Outline Application with some matters reserved for 1No. 5 person 3 bedroom bungalow, with 8No. parking spaces, bin and cycle store

Land adjacent of 14 St Johns Close Westergate Aldingbourne

Thank you for your internet representation made on 3rd January 2017 which has been recorded as '**an objection**' with the comments as follows:

location plan &
proposed site plan

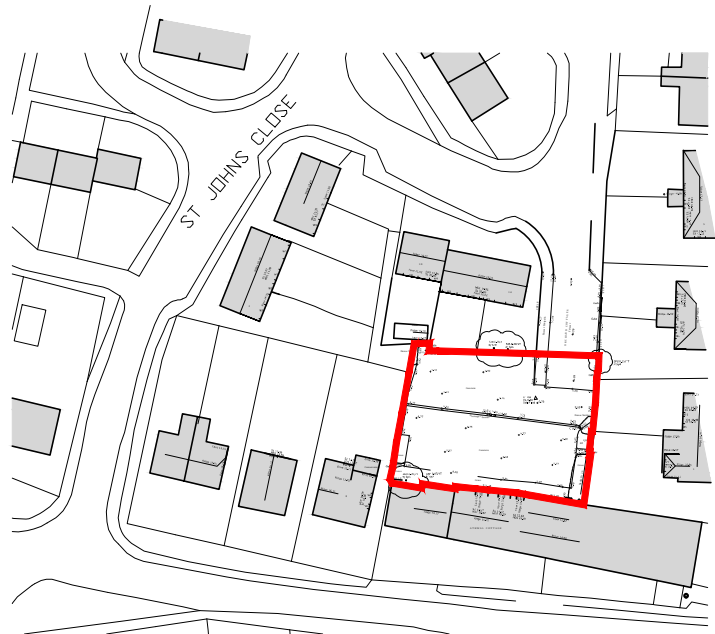
From looking at the plan, part of the area the rear of 3 Orchard Cottages has been allocated as re-provided parking. We have 2 young children and 2 cars not being able to park to the rear of our property will increase the risk of them being put in danger and cause us all a massive inconvenience.
